From: Glenn Gasson [REDACTED]
Sent: 02 November 2021 15:18
To: Simon Davis
Cc: Laura Gibbons
Subject: RE: Planning Consultation on: A/212/21/DOC
Attachments: C1249_300_C_Drainage Details 1 of 2.pdf

Formpave Diffuser tank construction

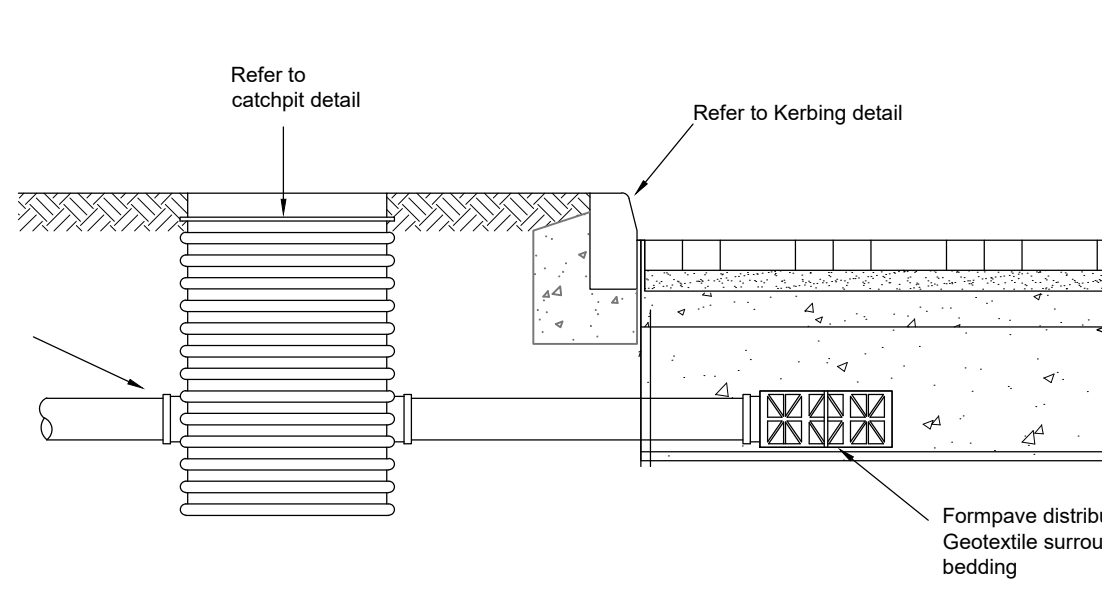
- It appears that there are some errors with the levels stated, please can the applicant review to ensure any typos are corrected to ensure that diffusers are located above formation level and a gravity connection from paving areas to the surface water drainage network can be achieved. The construction detail drawing implies that diffusers are the inlets to the permeable paving and that fin drains are proposed as outlets. However the arrangement of the diffusers and the levels stated on the layouts imply that the diffusers are actually being used as collectors at the base of permeable paving. My understanding is that the permeable paving is meant to infiltrate with high level overflow to the network, therefore levels should be revised so that the diffusers/ collectors are not set at the very base of the sub-base - I've revised the details to include the diffuser unit which is the Formpave diffuser unit detail used on site.
